Our Ref: SSP/SW/Pill

Your Ref: TR040011

12<sup>th</sup> January 2021

**RE: APPLICATION BY NORTH SOMERSET DISTRICT COUNCIL FOR AN ORDER GRANTING DEVELOPMENT CONSENT FOR THE PORTISHEAD BRANCH LINE – METROWEST PHASE 1**

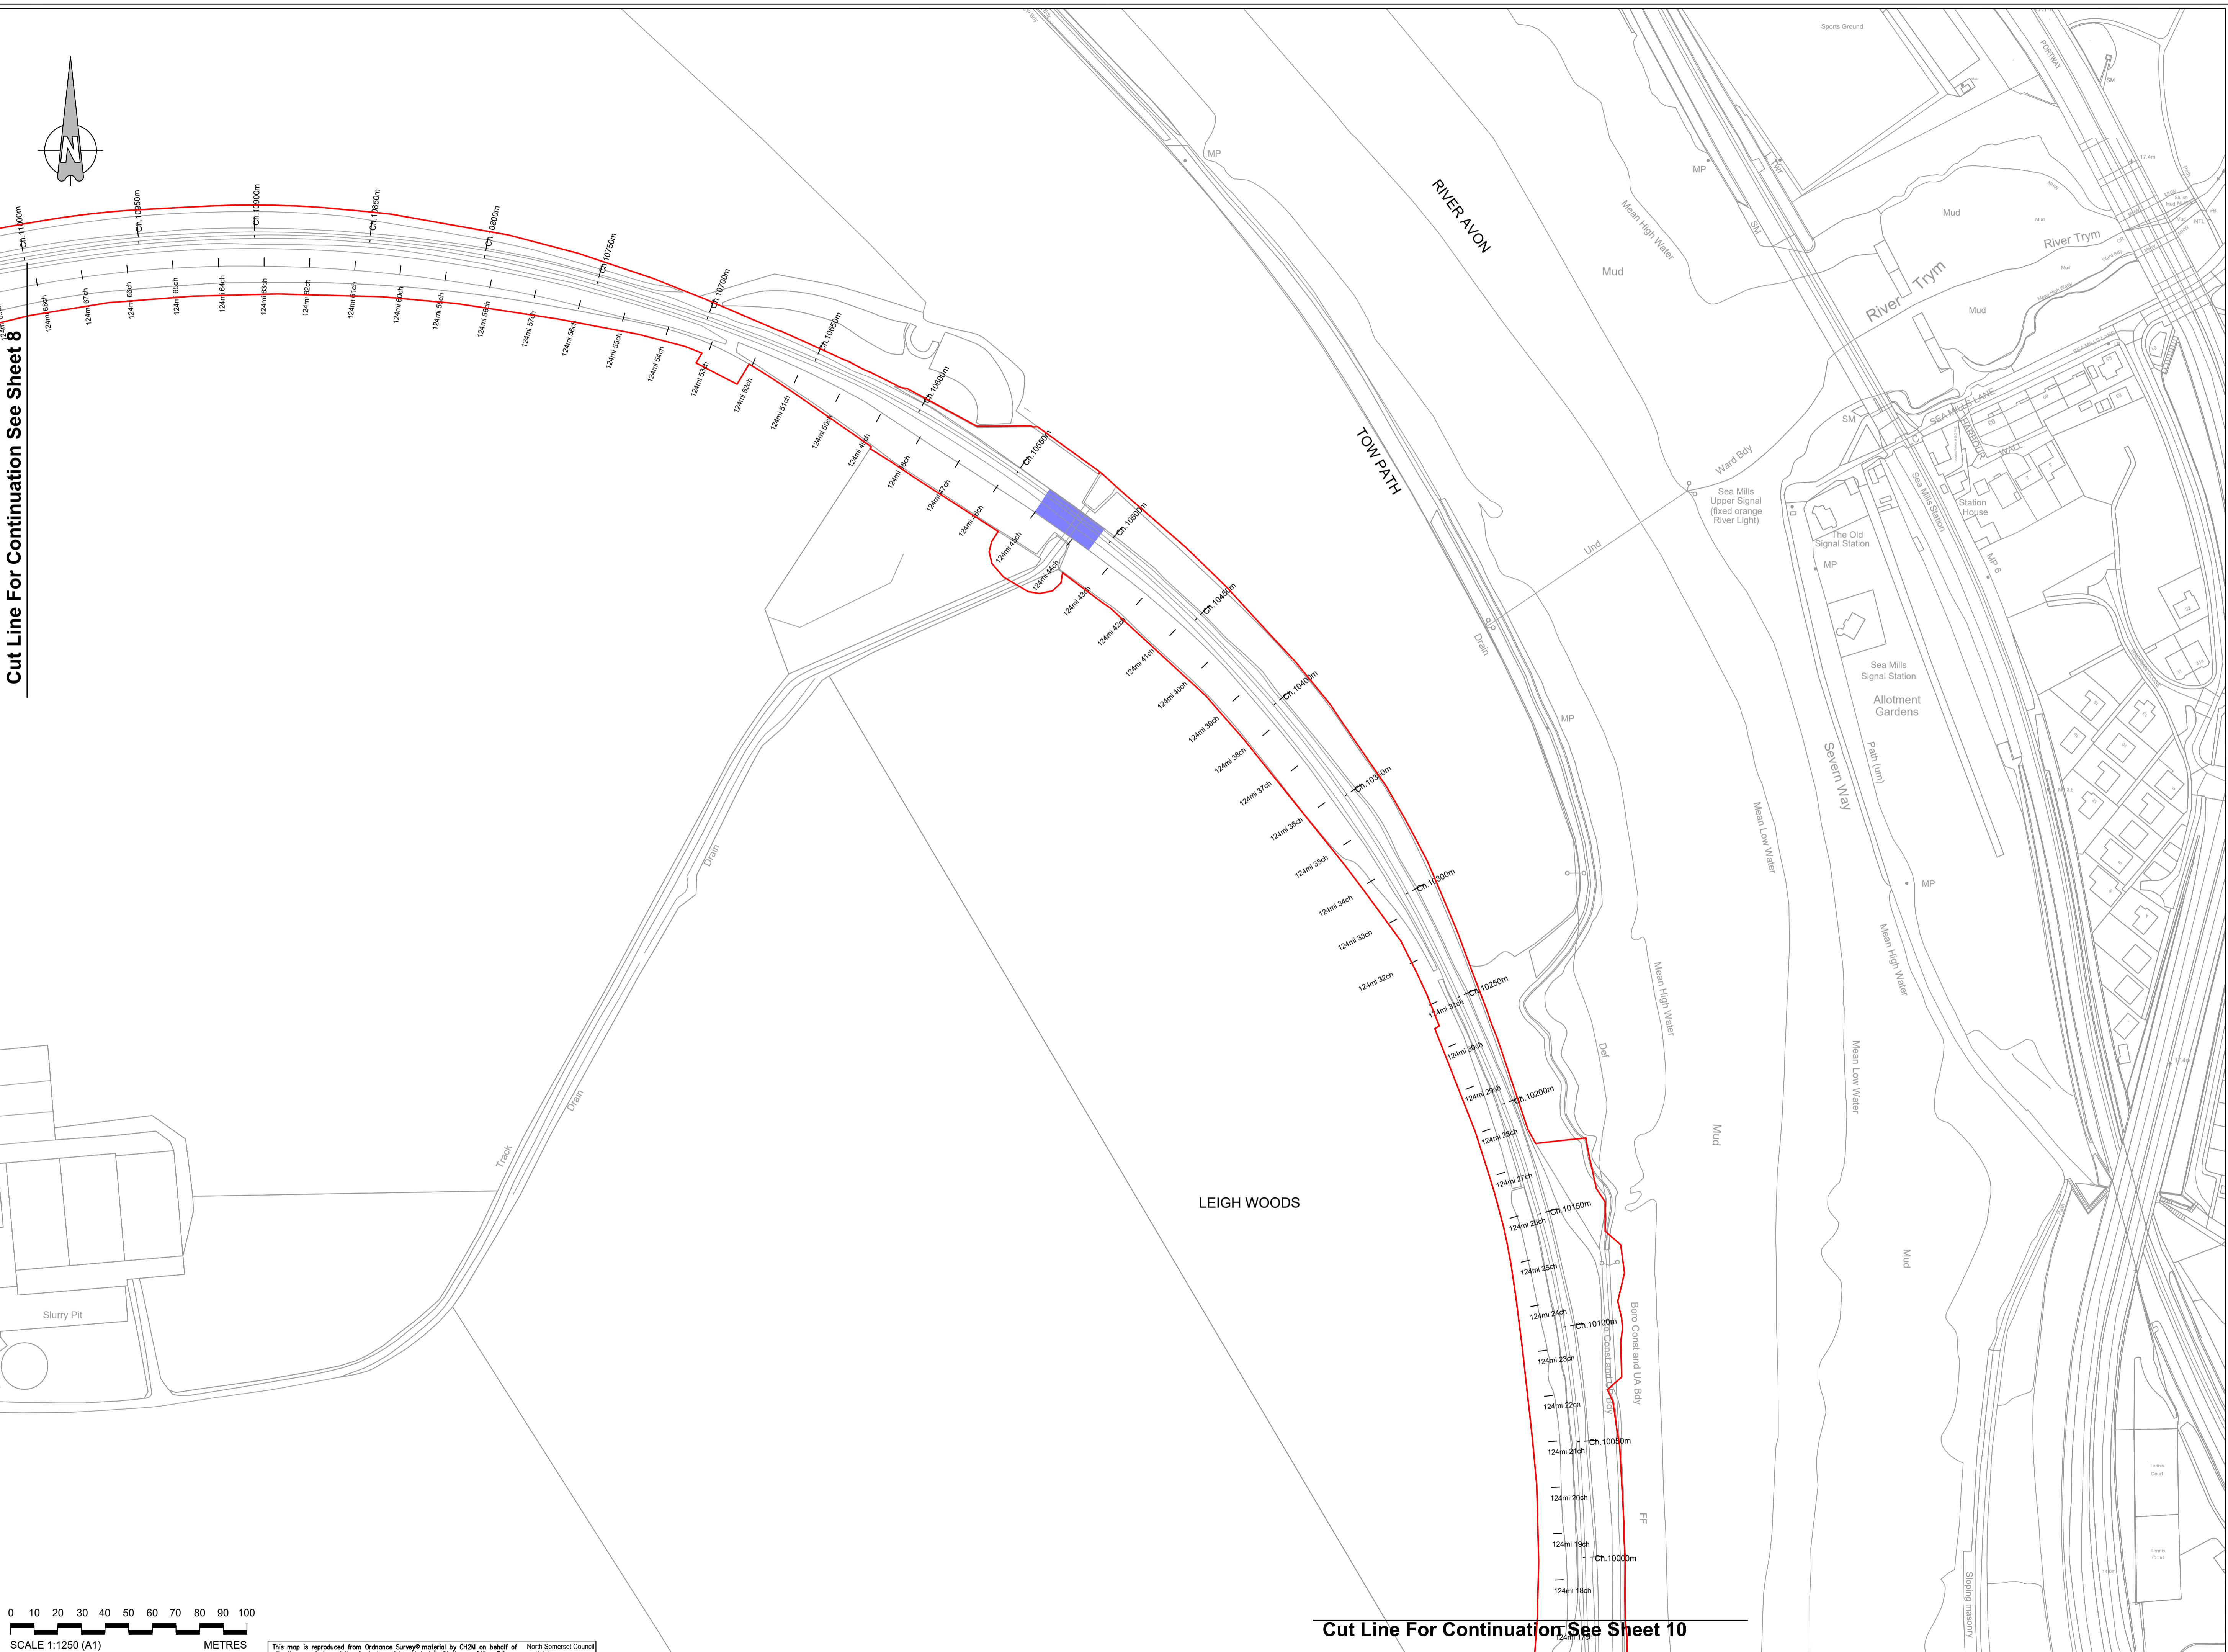
Although we recognise this may be a little late in the day it is our view that with some very simple changes in the route of the service roads VERY SIGNIFICANT environmental damage and local disturbance can be avoided.

Rather than using the proposed routes as shown on Sheet 9 (attached) we suggest a direct access route is constructed directly from Pill Road as shown on our sketch attached.
